From: Simon Davis
Sent: 18 September 2018 11:02
To: 'Orchard Enterprises'
Subject: BR/219/18/PL 9 Westloats Avenue

Block Plan 1 : 500

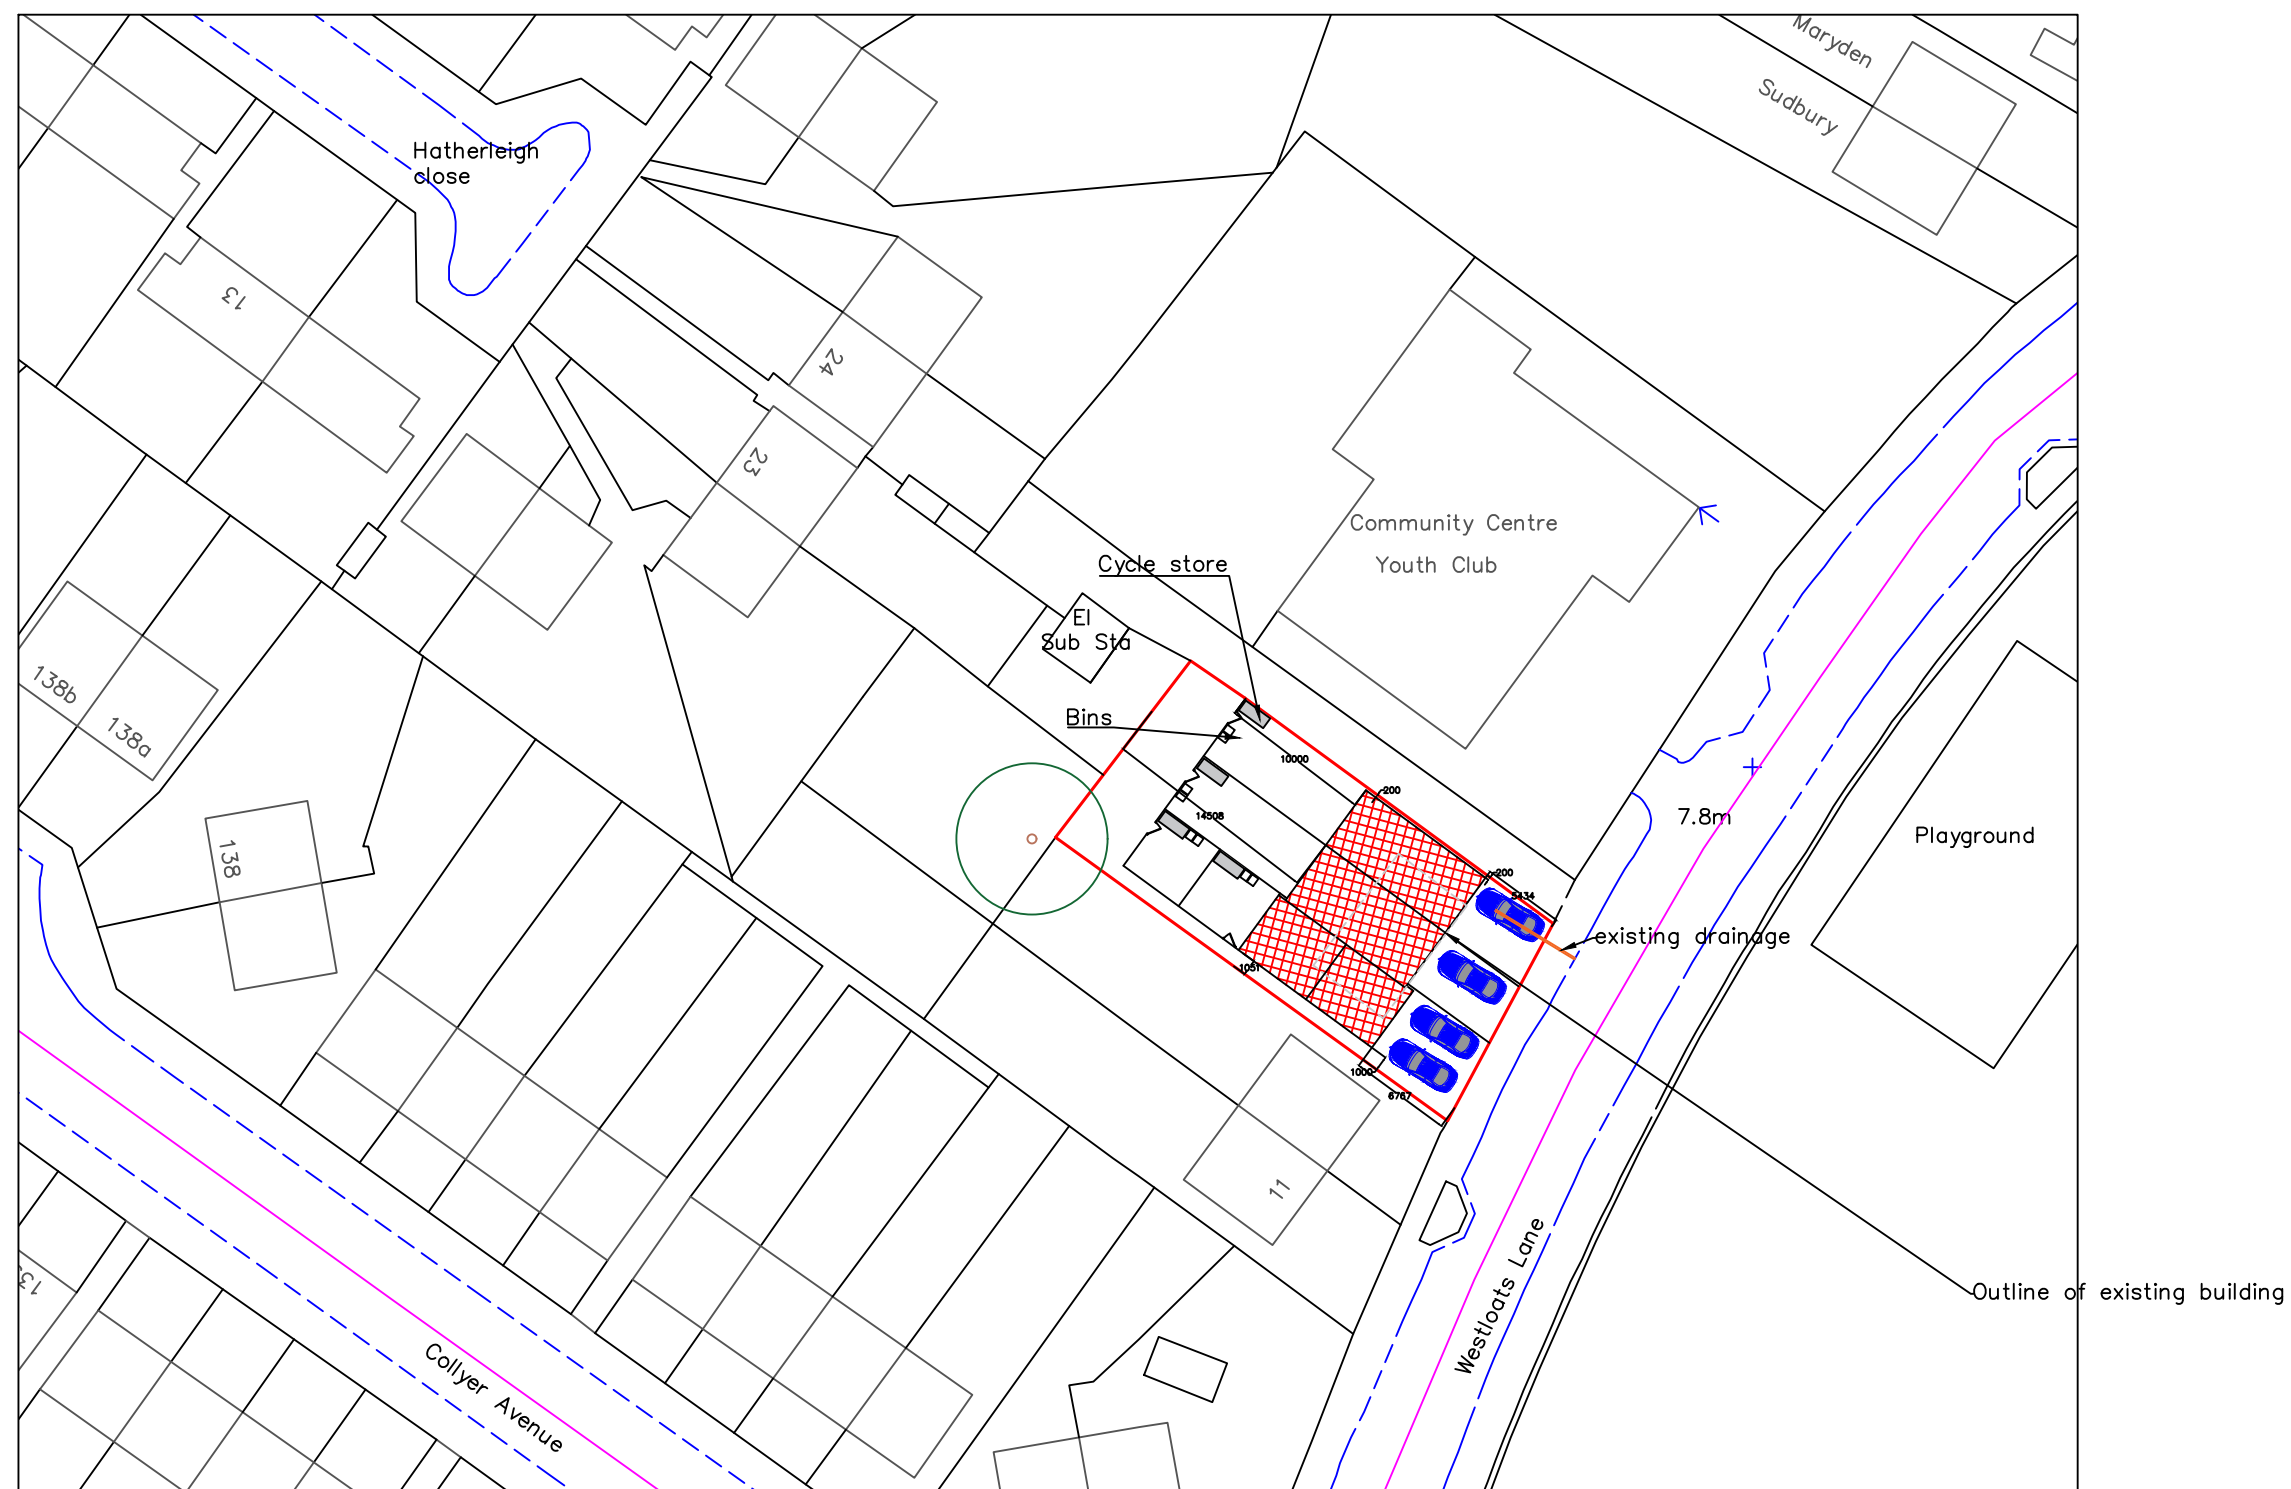
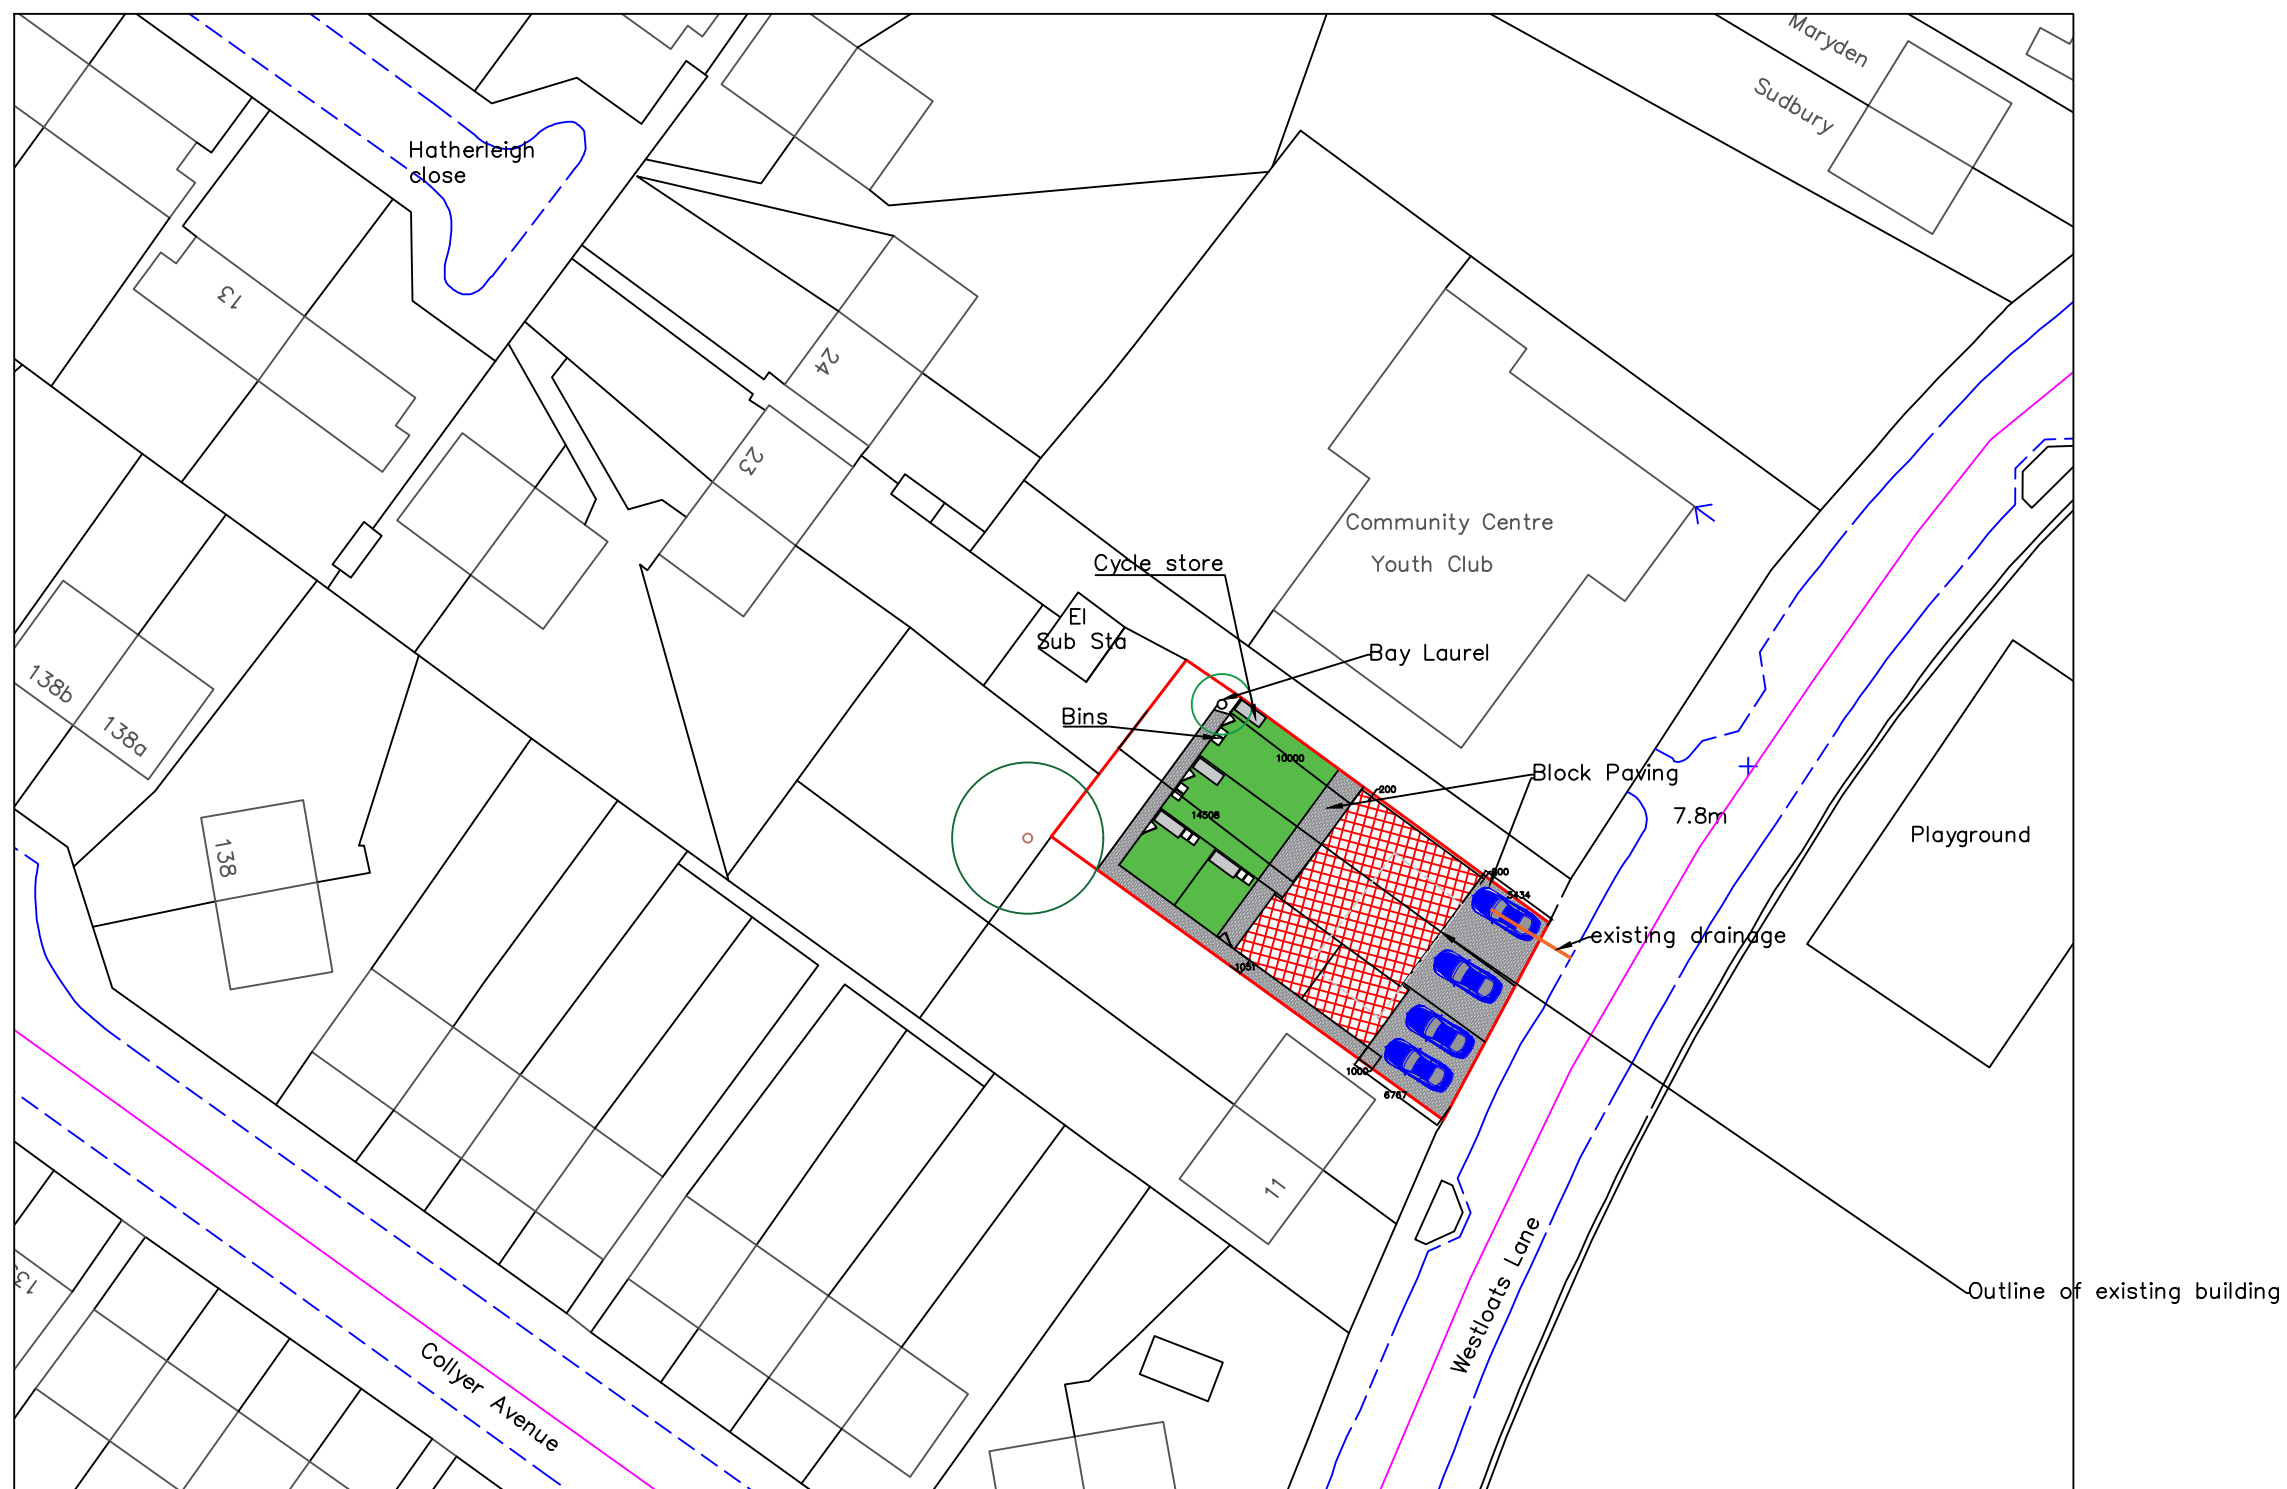
I have just been looking at your application and I have a question. What is to happen with the land between the rear gardens and the back edge of the site. I get that there needs to be communal access to the rear gardens but there seems to be quite a lot of space left over which could end up not being looked after.
